From: Planning 
Sent: 05 December 2018 11:52
To: Simon Davis
Cc: James Potter
Subject: Re: FP/171/18/PL - pre commencement conditions

From: Simon Davis
Sent: 30 November 2018 13:23
To: 'Planning'
Cc: 'James Potter'; 'Lauren Wiltshire'; 'Damian Haley'; 'Ian Wallace'
Subject: RE: FP/171/18/PL - pre commencement conditions

I need to agree the proposed pre-commencement conditions with you before our recommendation report is finalised. These are in the attached document. Please can you let me know whether you can agree to these.

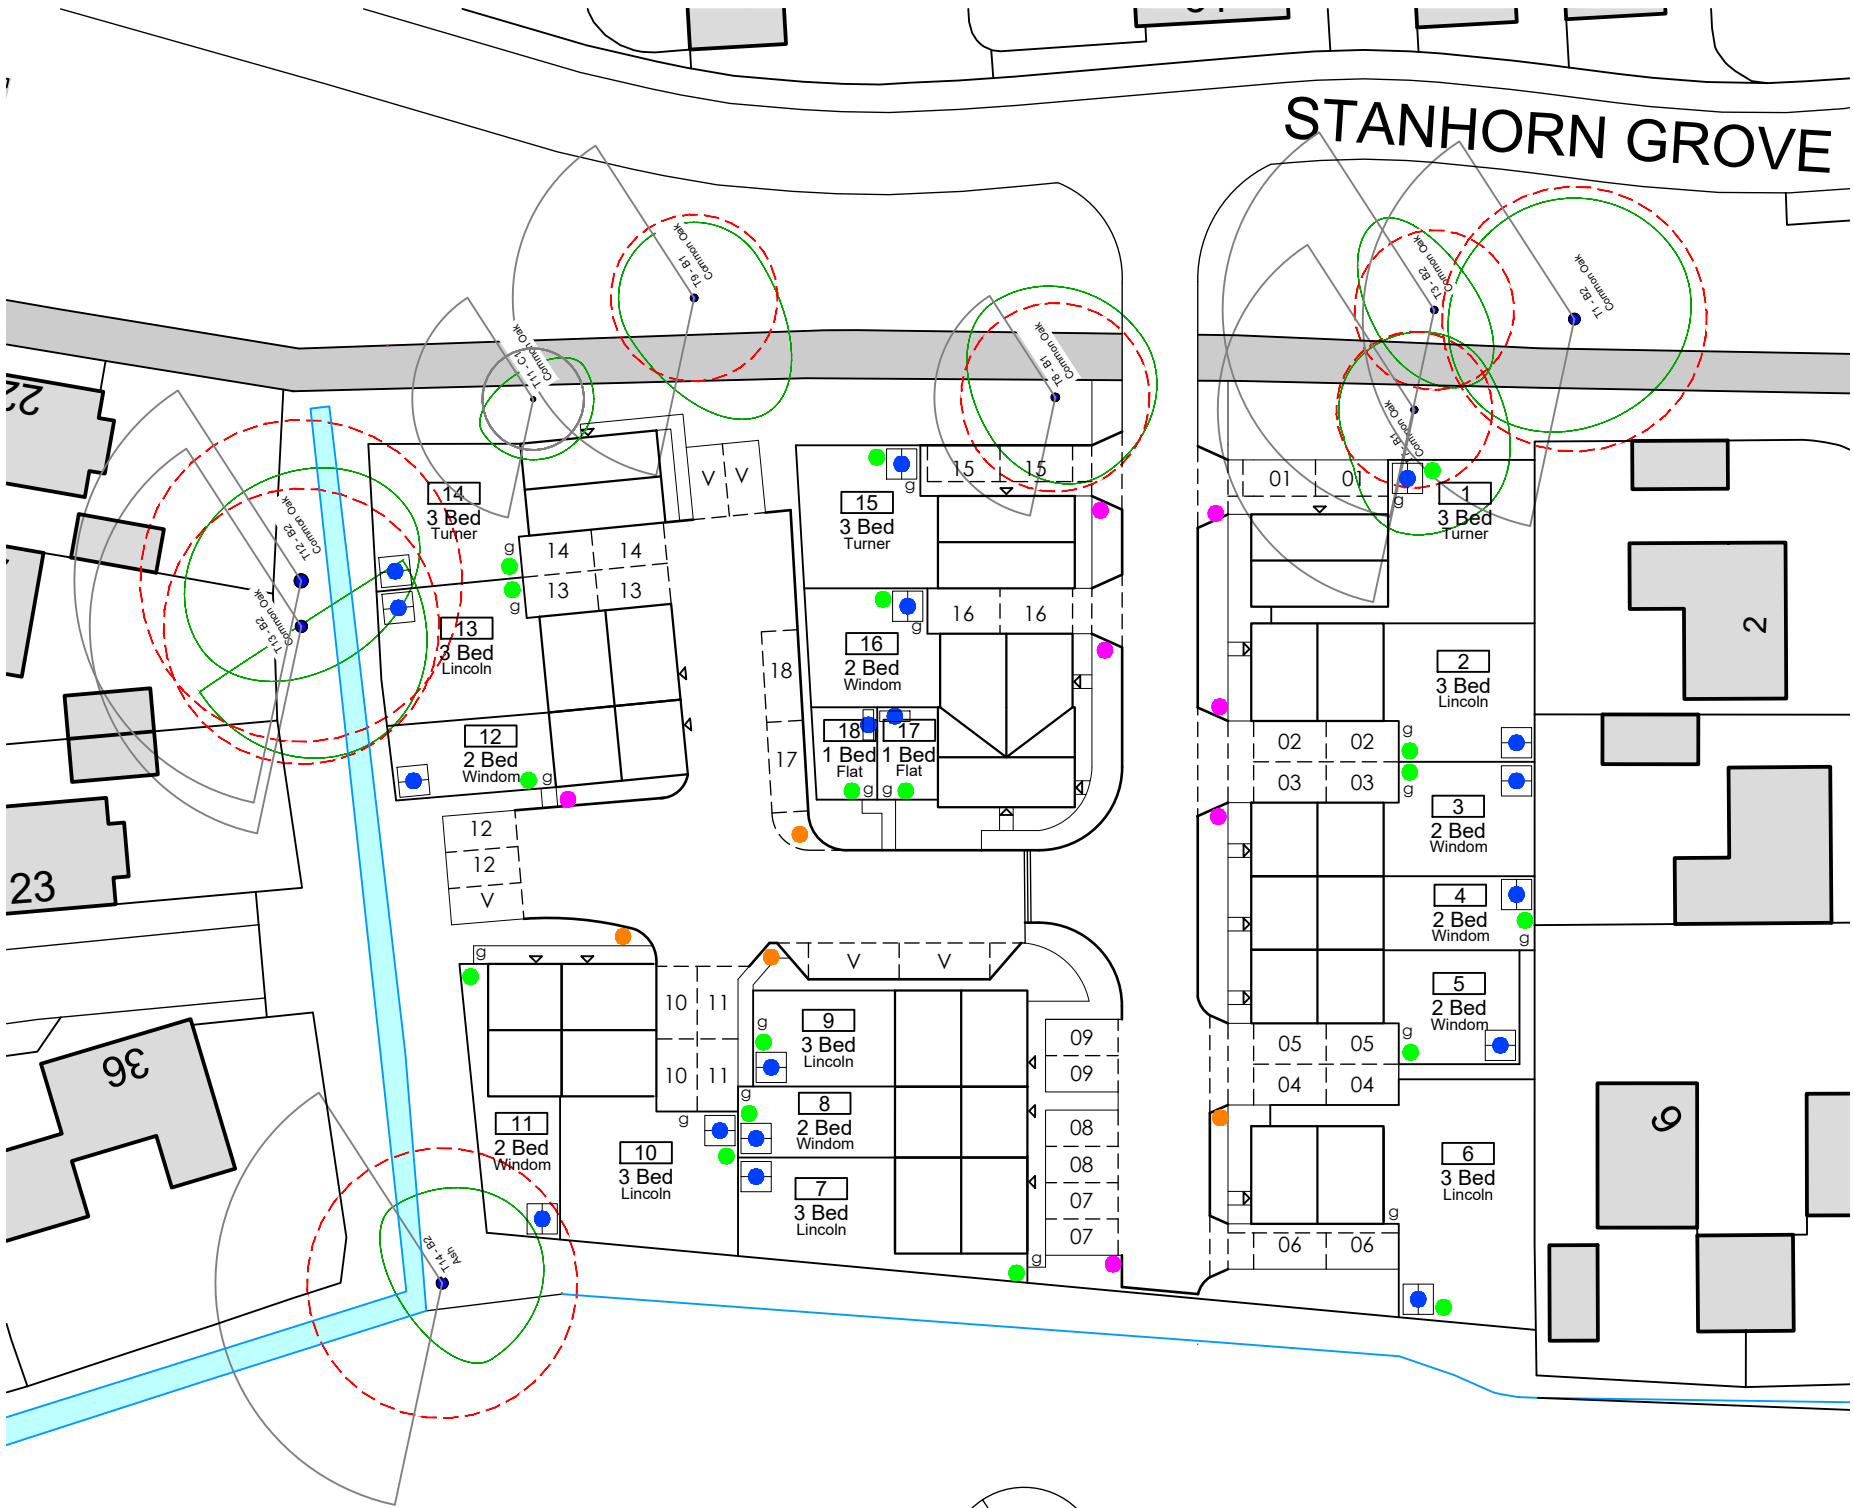
As regards the non-pc conditions, I have amended the typo in the plans condition and also amended the car and cycle parking conditions as follows.

Car Parking - No dwelling within the site shall be occupied unless and until the car parking associated with it has been constructed in accordance with the approved site layout parking/cycle parking plan (17094-PL-2-08 Rev D). The final dwelling on the site shall not be occupied unless and until all of the proposed unallocated visitor spaces have been constructed in accordance with the

same plan (17094-PL-2-08 Rev D). These spaces shall thereafter be retained at all times for their designated purpose.

Cycle Storage - No dwelling within the site shall be occupied unless and until covered and secure cycle parking spaces to be associated with that dwelling have been provided in accordance with the approved site layout parking/cycle parking plan (17094-PL-2-08 Rev D). The secure cycle storage so approved shall be implemented in accordance with the approved details and retained in perpetuity unless otherwise agreed in writing with the local planning authority.

Thank you for amendments to non-pc conditions - accepted.
